Your ref:
Our ref: 21/02430/F
Please ask for: Miss Sandra Homcenko
Direct dial: 01553 616824
Direct fax: 01553 616652
E-mail: borough.planning@west-norfolk.gov.uk

Details: **Replacement and additional perimeter fencing and gates and replacement of timber windows with white UPVc windows. at Southery Primary School 7 Westgate Street Southery Norfolk PE38 0PA**

I have received a planning application as detailed above but cannot process it until I receive some more information:

D03339/21/1/P03

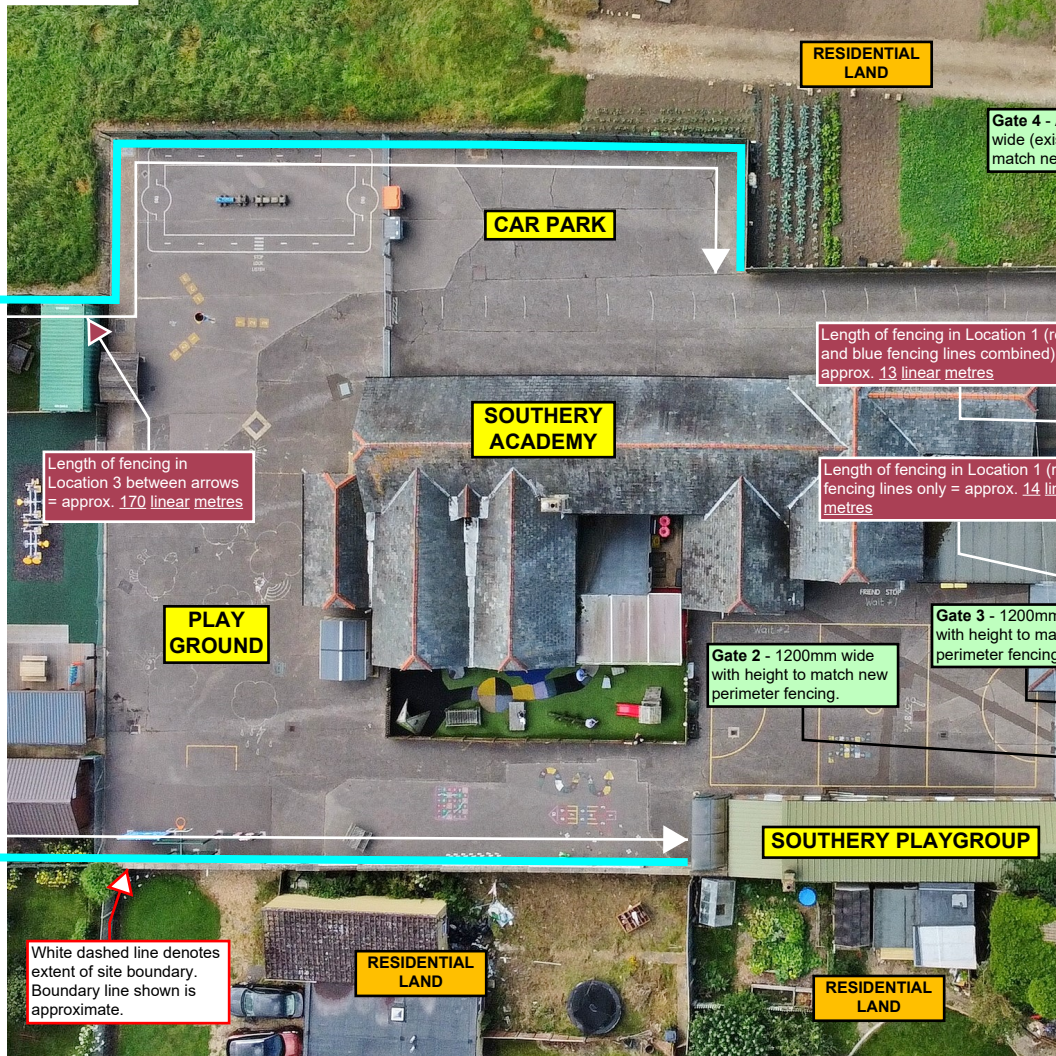
1. Please provide Proposed Elevations plan for all windows to be replaced, showing correct type of windows to be used reflecting those marked on drawing D03339/21/1P01
2. Although you have filled Certificate B with this application, drawing D03339/21/1/P03 suggests that the ownership of a boundaries are unknown, it appears that it would be required to follow procedures under Certificate C instead, please do not hesitate to contact us if you wish to discuss this further
3. Thank you for providing manufacturers document for fencing and gates. Apologies, however it is not clear what type of a fence/gate is applicable to locations marked on drawing D03339/21/1/P03, therefore please provide elevations for all fence and gate types you seek permission for.
